Document name: 231022-EDGE-XX-XX-CO-C-0001_LLFA RESPONSE [P01]

Re: LLFA RESPONSE – Drainage Comments – 148-154 High Street, Uxbridge – 78696/APP/2024/867.

2 Roof Plan
1:200

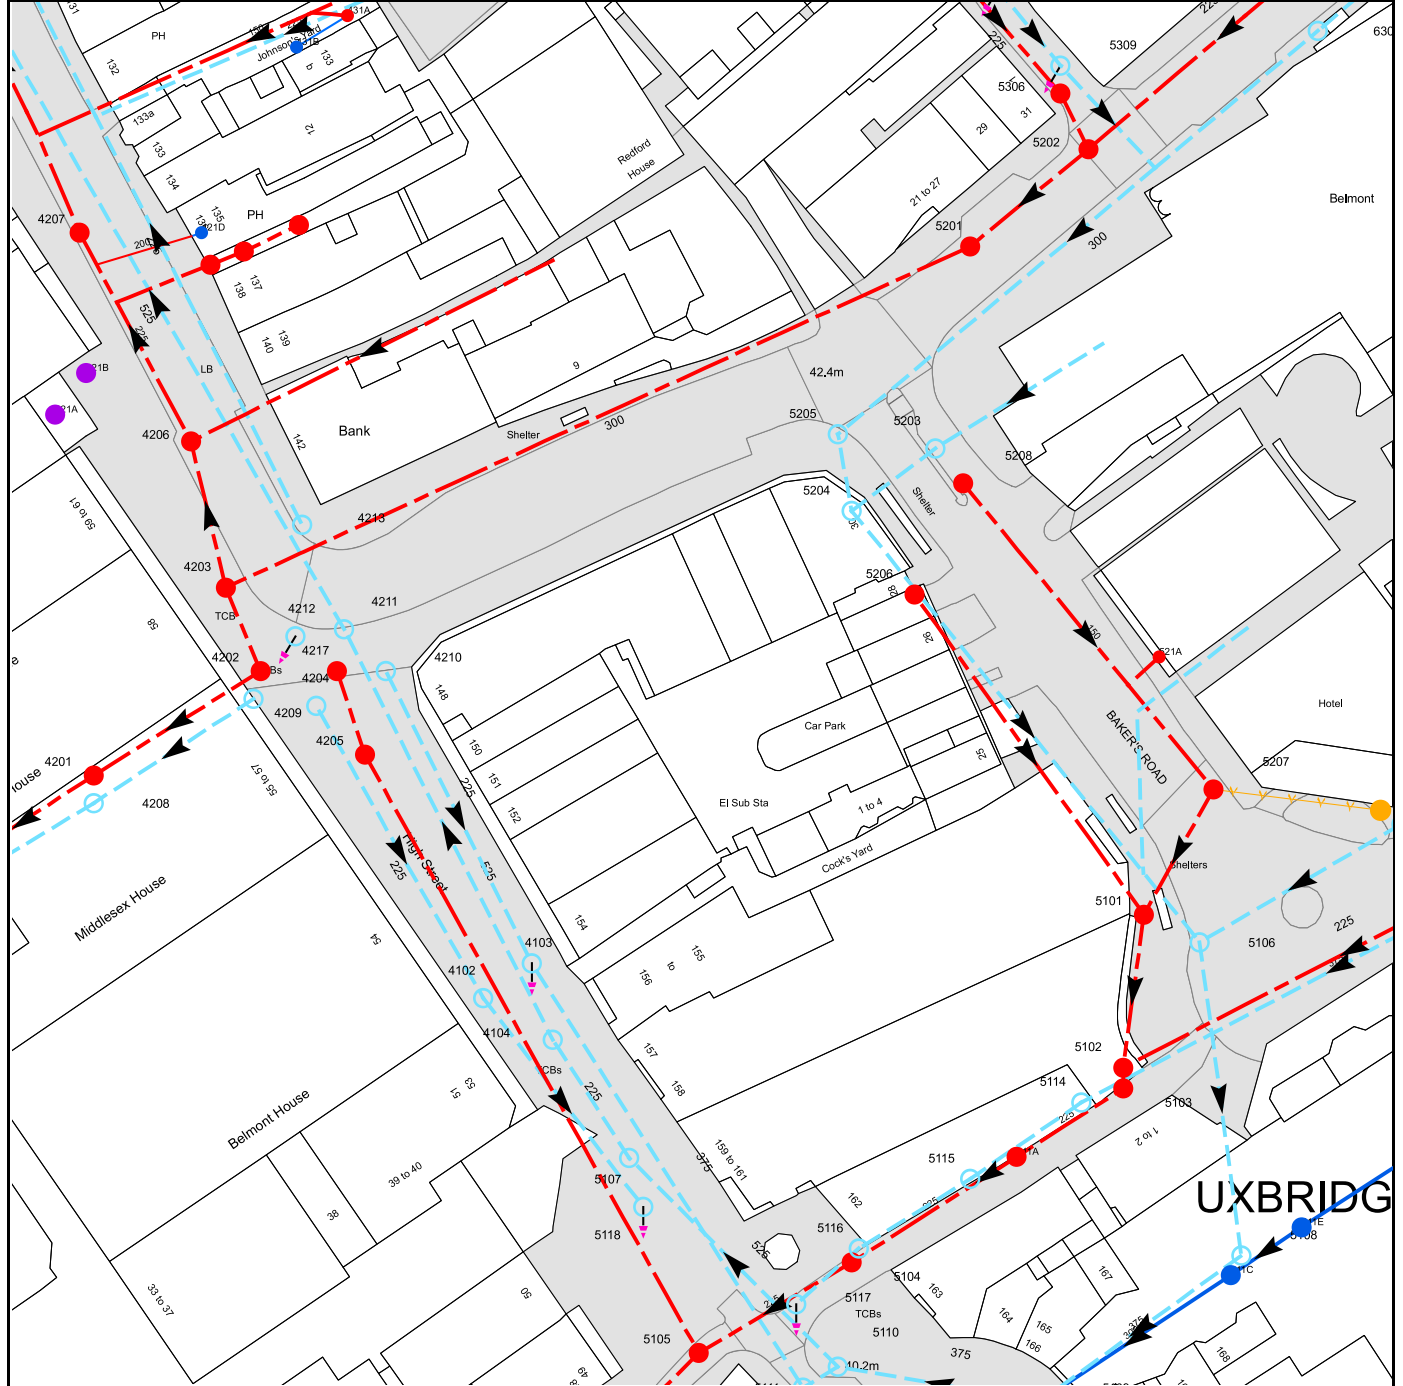
- 1. Confirms the system to be used on the roof, with typical details supplied and an indication of the location on the drainage drawing. This should confirm the storage available within the blue roof once the design has been confirmed.*

- 2. Confirms the existing surface water sewer connections and which connections will be retained.*
- 3. Demonstrates that the proposed runoff rate has been restricted as much as possible considering the site constraints, by showing in a drawing the extent of the roof which is available for the blue roof and providing calculations demonstrating the storage provided with the runoff rates.*

1. Please find attached enclosed architectural plan UXB-CGL-Z2-09-DR-A-SK50007-Blue Roof Drainage – ROOF PLAN which shows the areas designated for blue roof use along with a calculation package from blue roof specialist Bauder showing the storage volume that's achievable at a total restriction rate of 8.47 l/s. Bauders blue roof attenuation units are specified within the Bauder calculation package and a system summary/ typical detail document of the system is included in the accompanying package of information.

Note the total discharge rate will still be limited to 13 l/s however the roof plan shows some small areas of roof that will not be restricted by the blue roof system and an allowance for those areas to drain freely has been accounted for in the sites total runoff rate.
